Cambridgeshire County Council and Fenland District Council Relevant Representations

1 Introduction

- 2.1 Cambridgeshire County Council (CCC) and Fenland District Council (FDC) officers have engaged in pre-application discussions with Medworth CHP Limited to ensure that the final submission takes account of early concerns around the information and methodologies required to be able to fully assess their proposals. In the main this advice has been followed. However, as highlighted in the sections below, there are still some queries that need to be addressed to allow CCC and FDC to fully understand the impacts of the scheme and to form a view as to whether the mitigation measures proposed are sufficient.

Table 3.1 Nearest sensitive Receptors

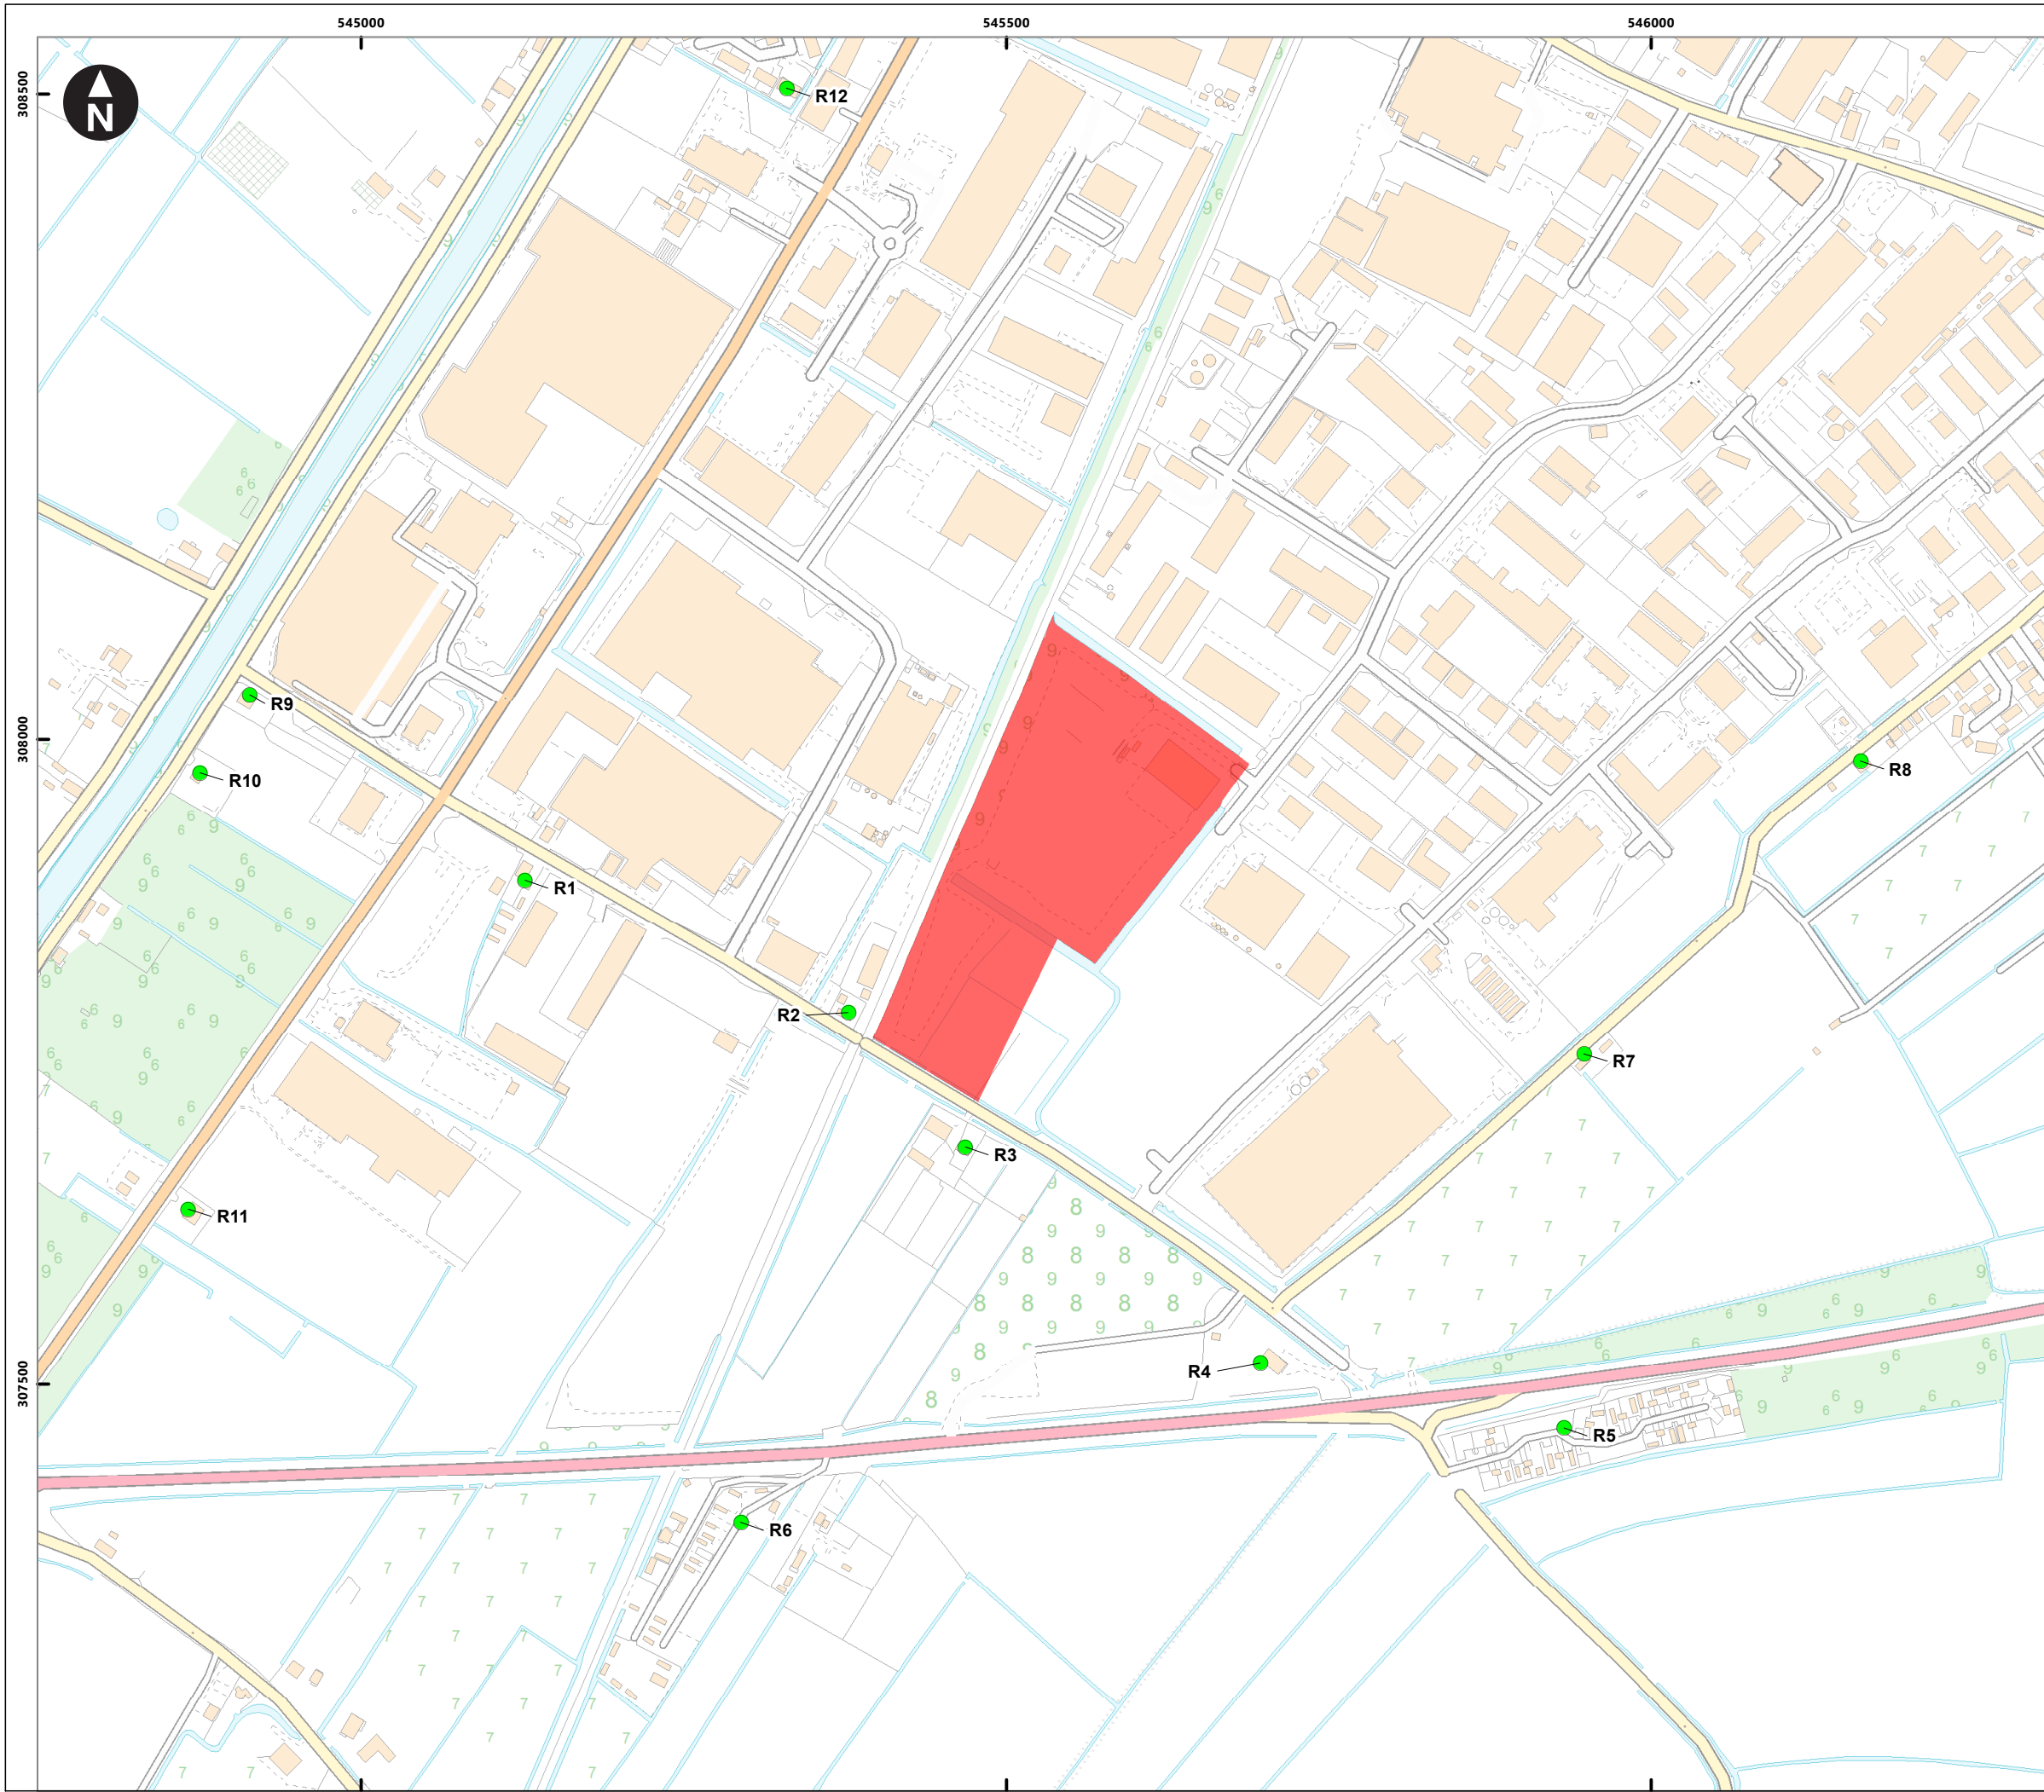
- 4.13 The Noise and Vibration Chapter (7) of the Environmental Statement does not identify the Thomas Clarkson Academy (TCA) as a noise sensitive receptor even though it is within 750 metres of the site and closer to the CHP Connection works. Whilst it is standard practice for a study area to be up to 300 metres, this is not a maximum and is only “normally sufficient” according to the relevant British Standard. The study area section does not acknowledge sensitive receptors such as the TCA and especially the external areas associated with the Academy’s play areas and sports pitches.

- 4.14 The TCA and Free School site falls within the study area for the EfW CHP as identified on figure 7.5 (Operational Noise Study Area). However, no long term or short-term monitoring is proposed to assess the impact of the proposed development on the school even though the southern boundary of the TCA site where the existing MUGA (Multi-Use Games Area) is located is identified as a ‘Noise Sensitive Receptor’. Whilst the noise modelling results suggest that noise levels will be between 35-40Db, given that the TCA should be regarded as a sensitive receptor, some acknowledgement and further consideration, along with monitoring to mitigate any real-time impact should be provided. Furthermore, on the basis that only short-term monitoring is proposed for the CEFLC and RMA school sites this also needs to be given further consideration and longer-term mitigation.
